Access Design Assessment Report

Picton High School Redevelopment  
480 Argyle Street  
Picton NSW 2571

Project: Picton High School Redevelopment  
 Document Type: Access Design Assessment Report  
 Report Number: P217\_007-2 (ACCESS) NH

Figure 4.3 Lower Ground Floor Plan  
 Billard Leece Partnership Pty Ltd (2018) Drawing No. AA10-0001

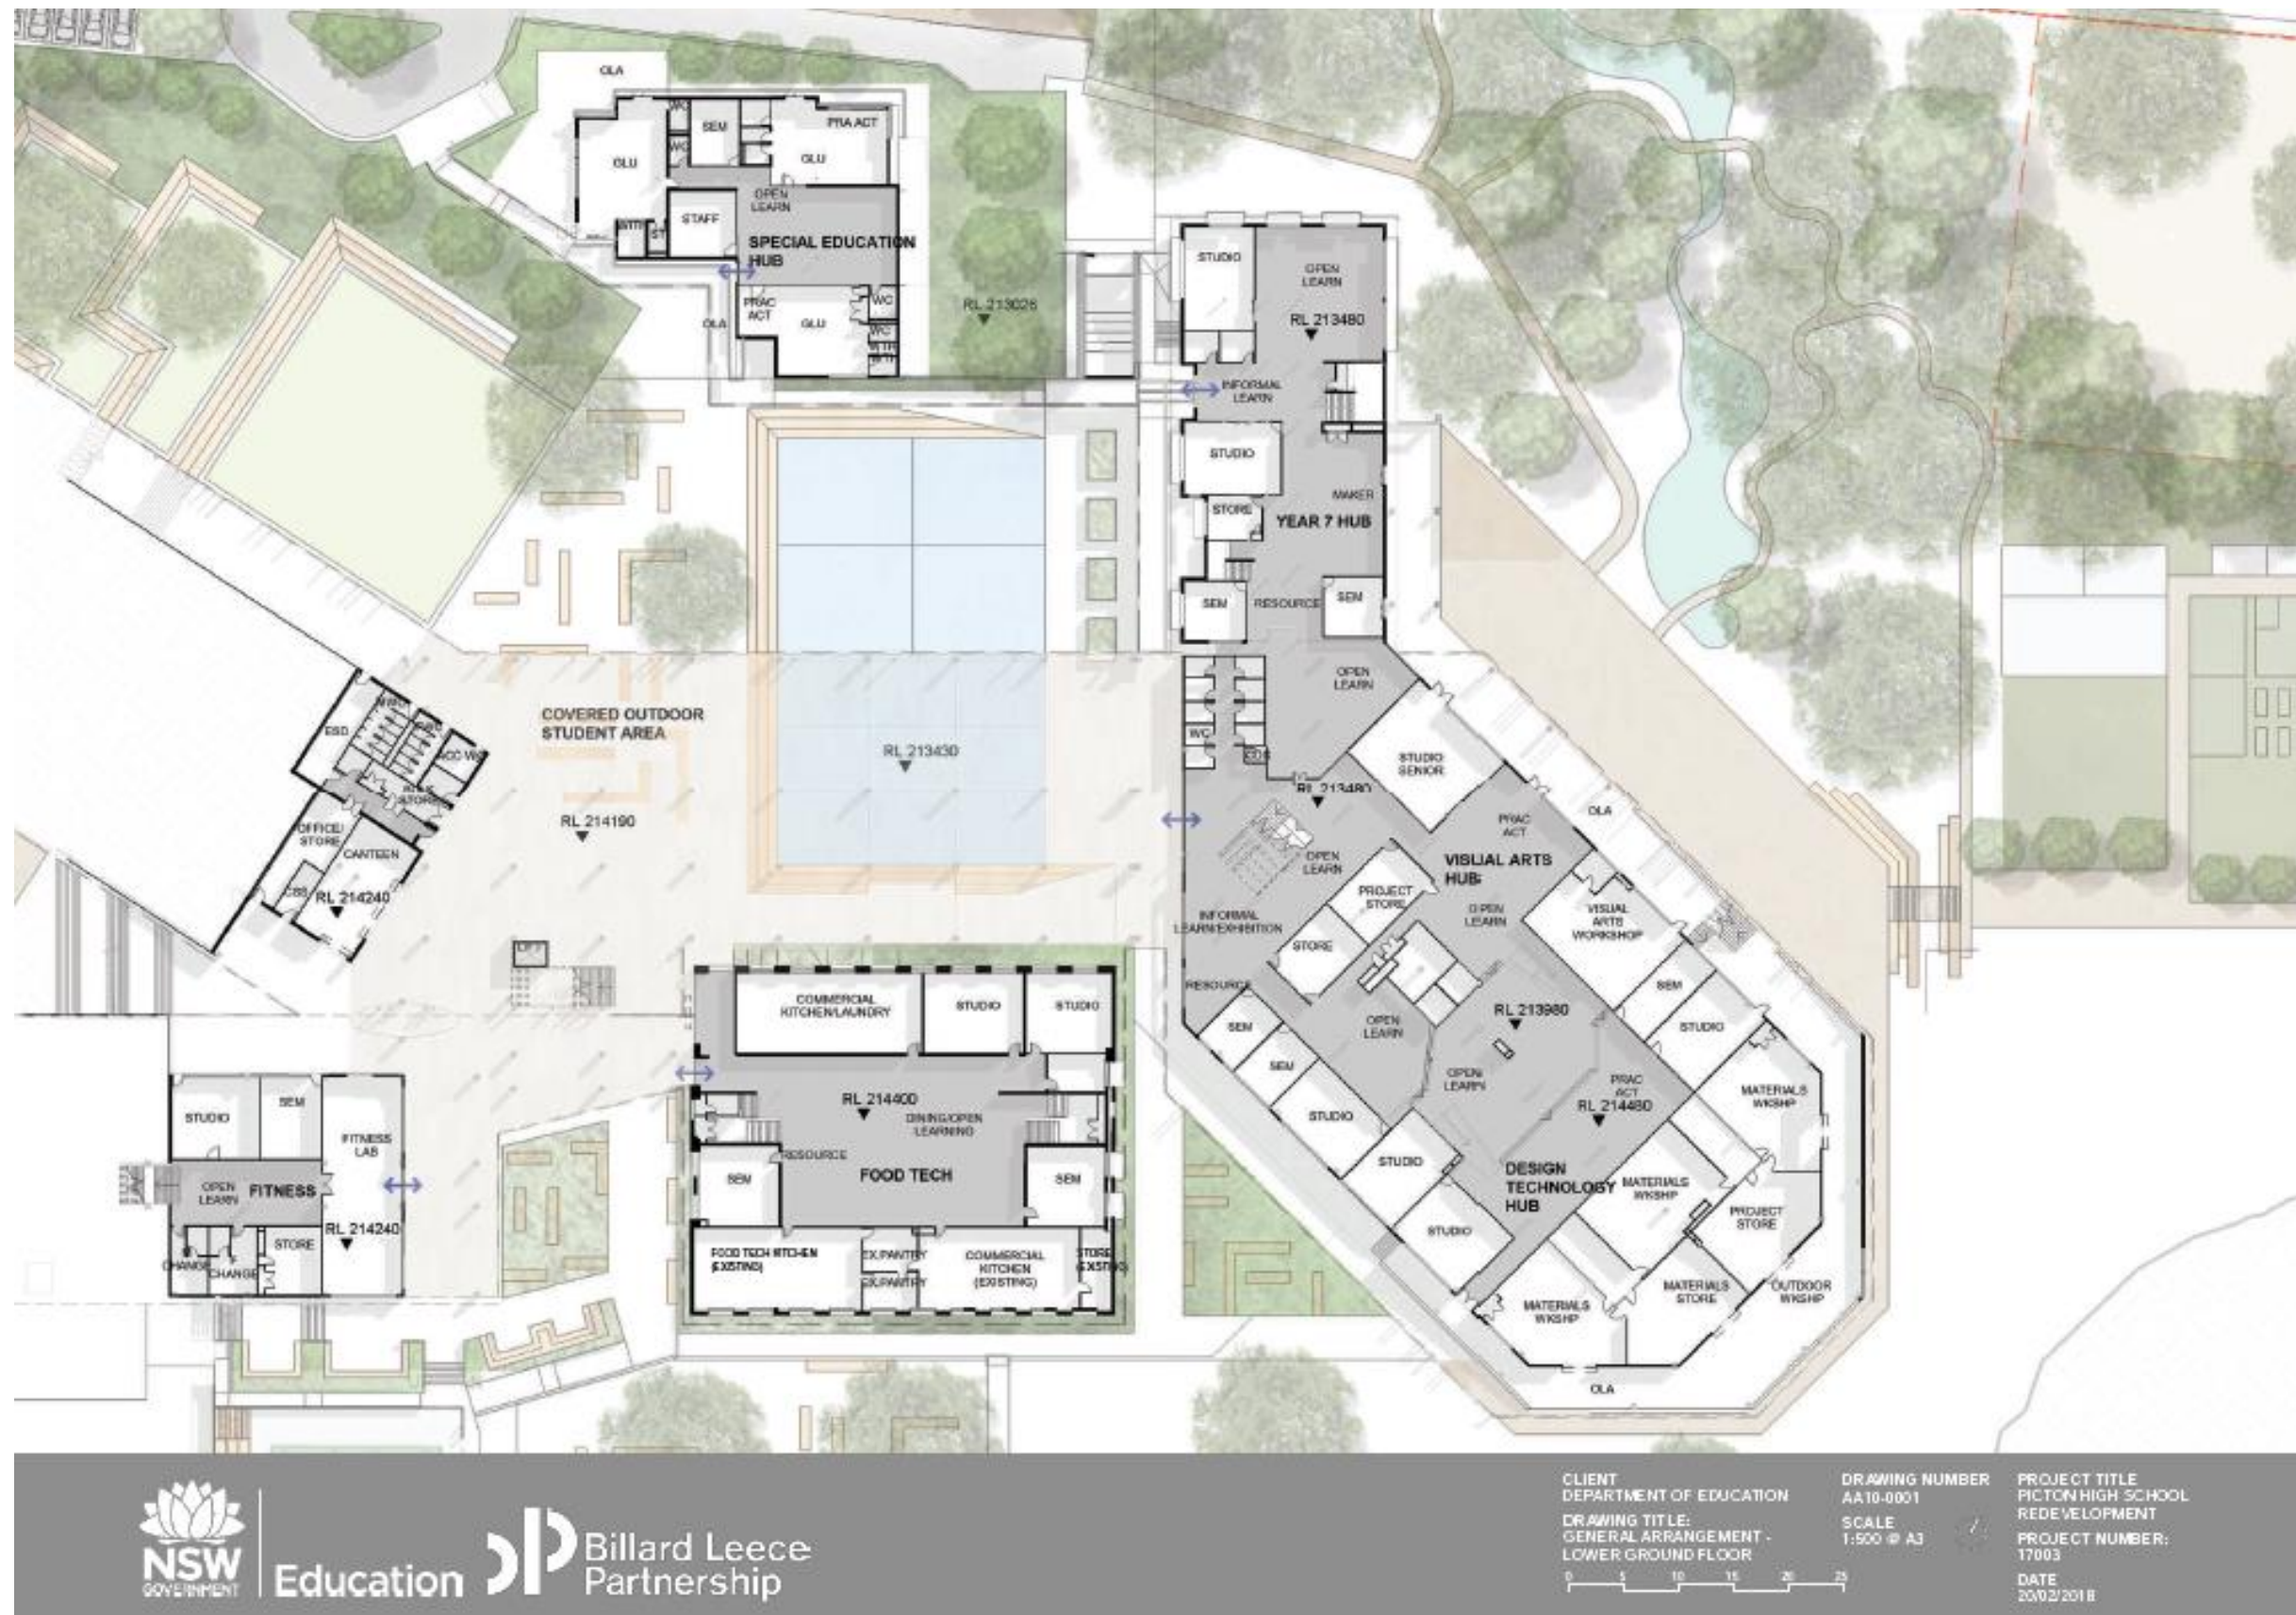
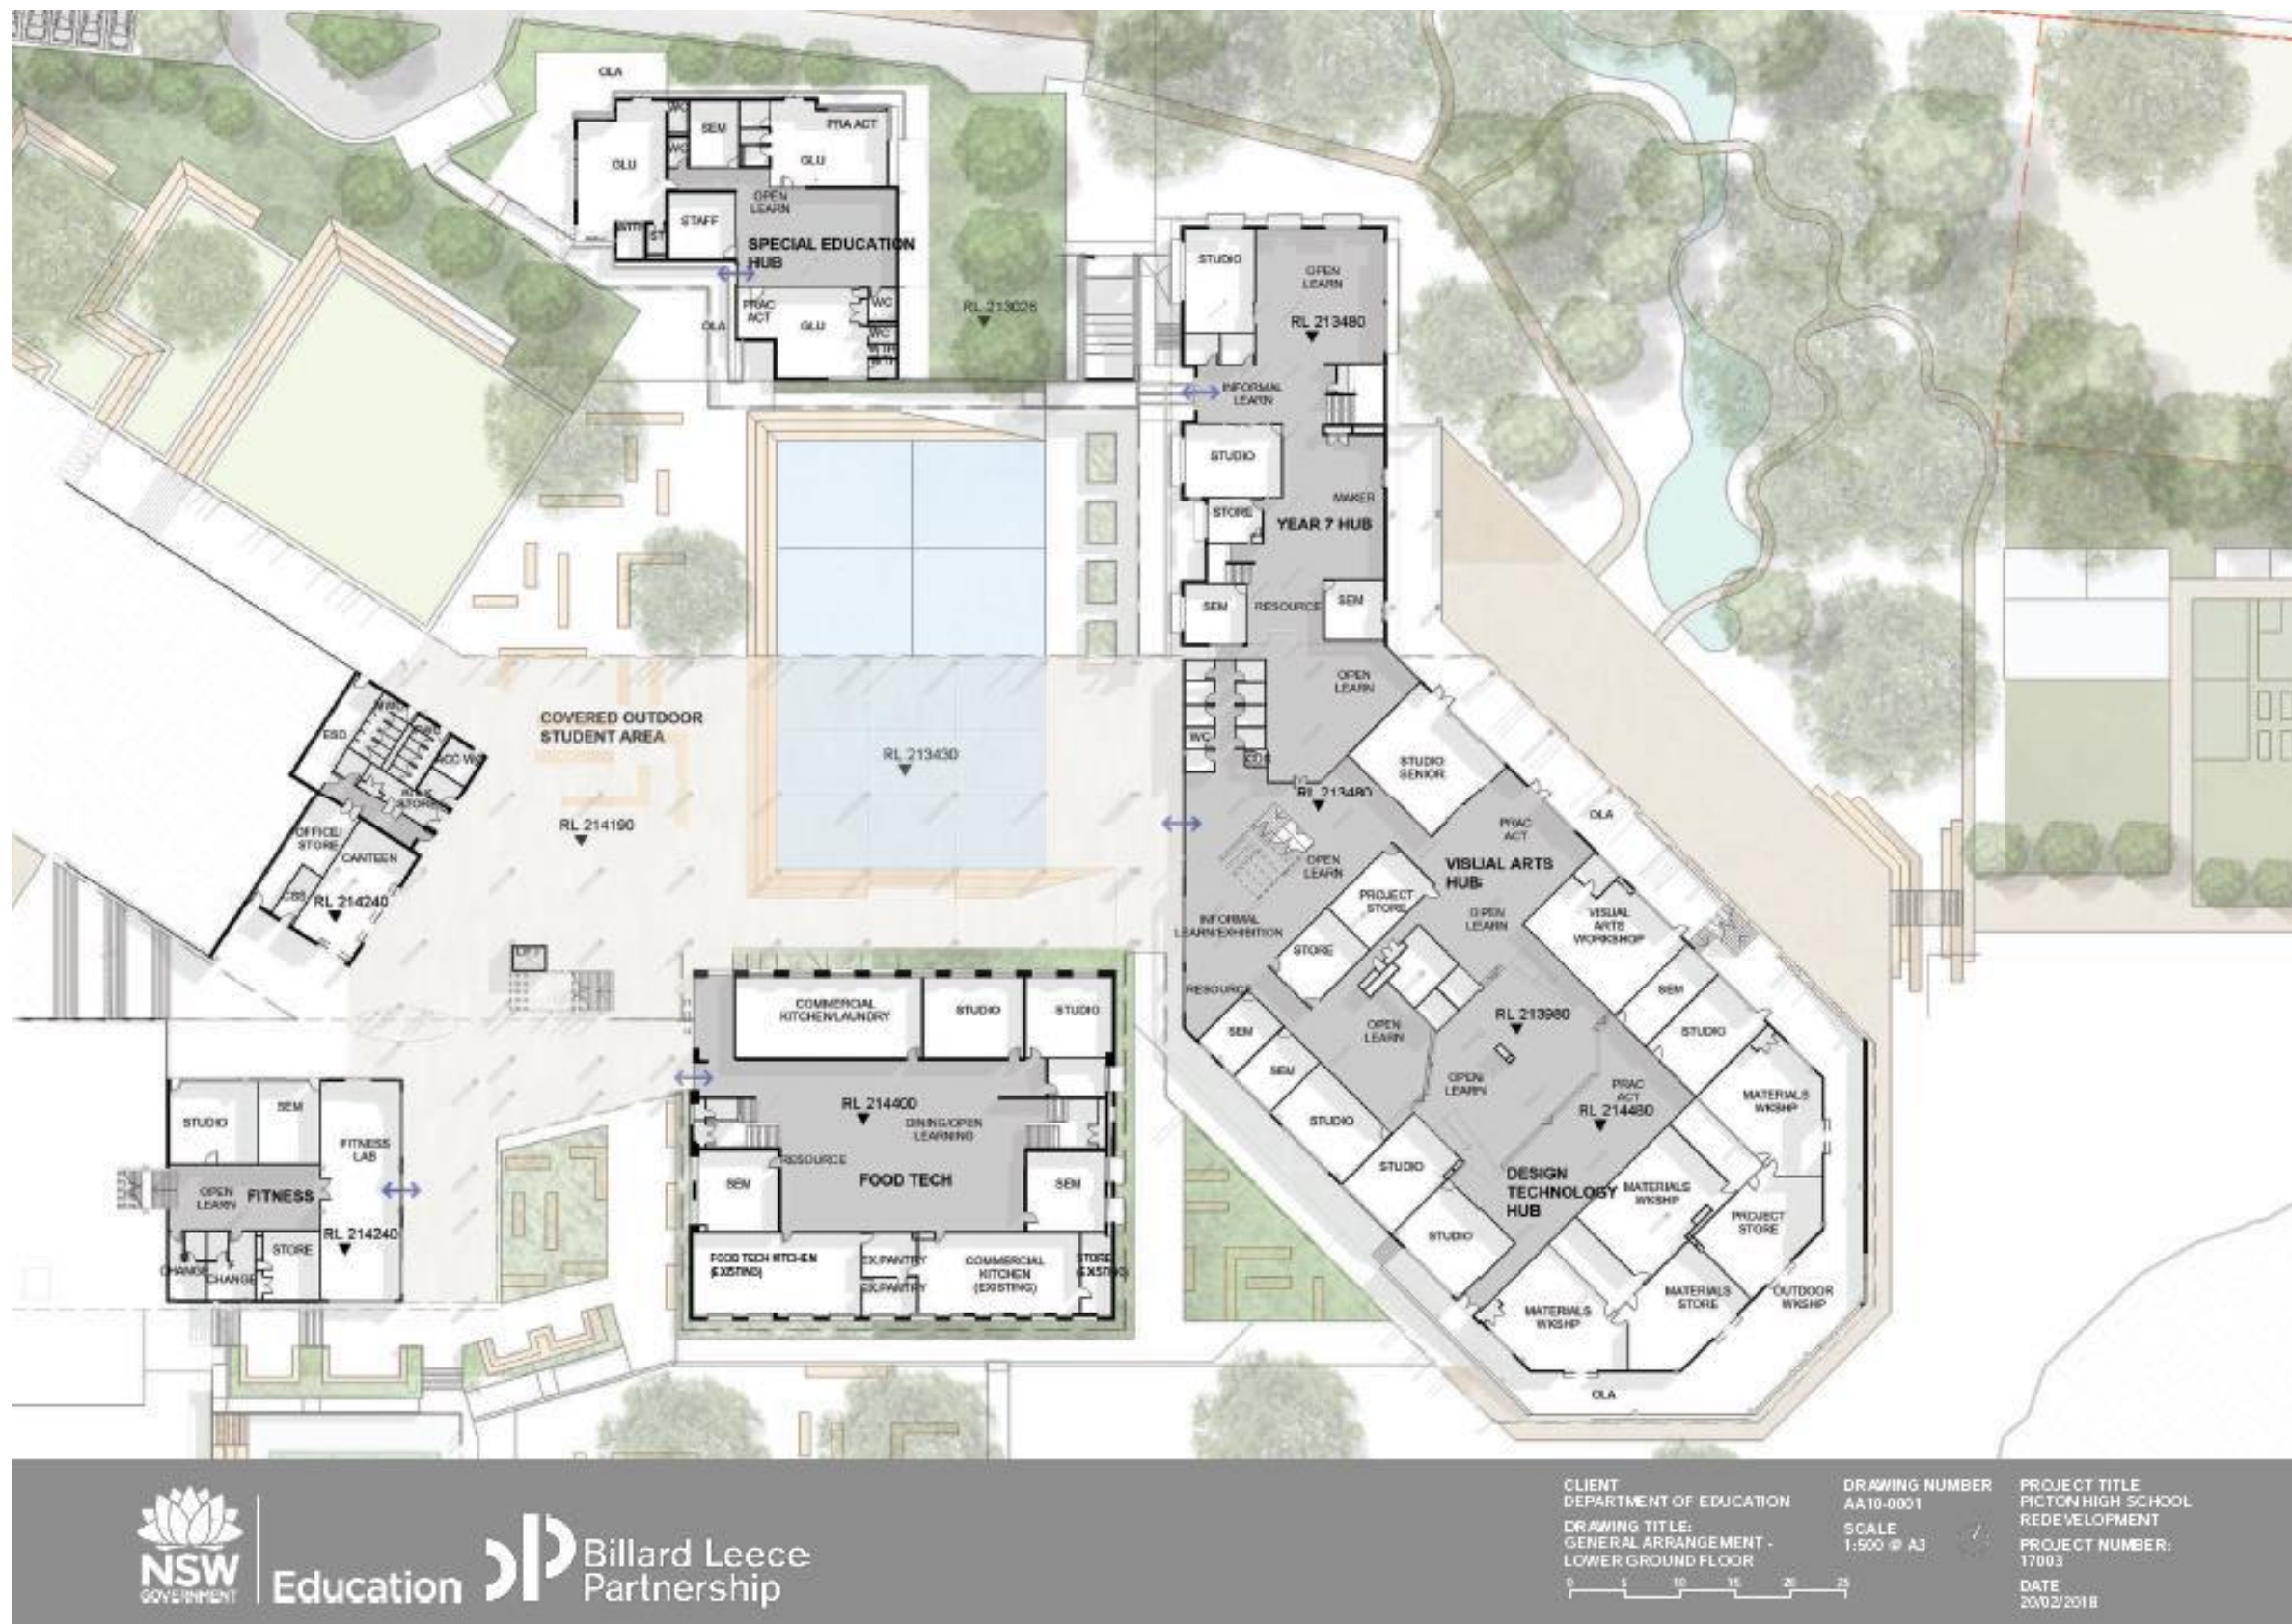
Concern is raised with a shortfall of access provided to and within the Design & Technology space located at the south-east corner of lower ground floor is provided with stairway access only.
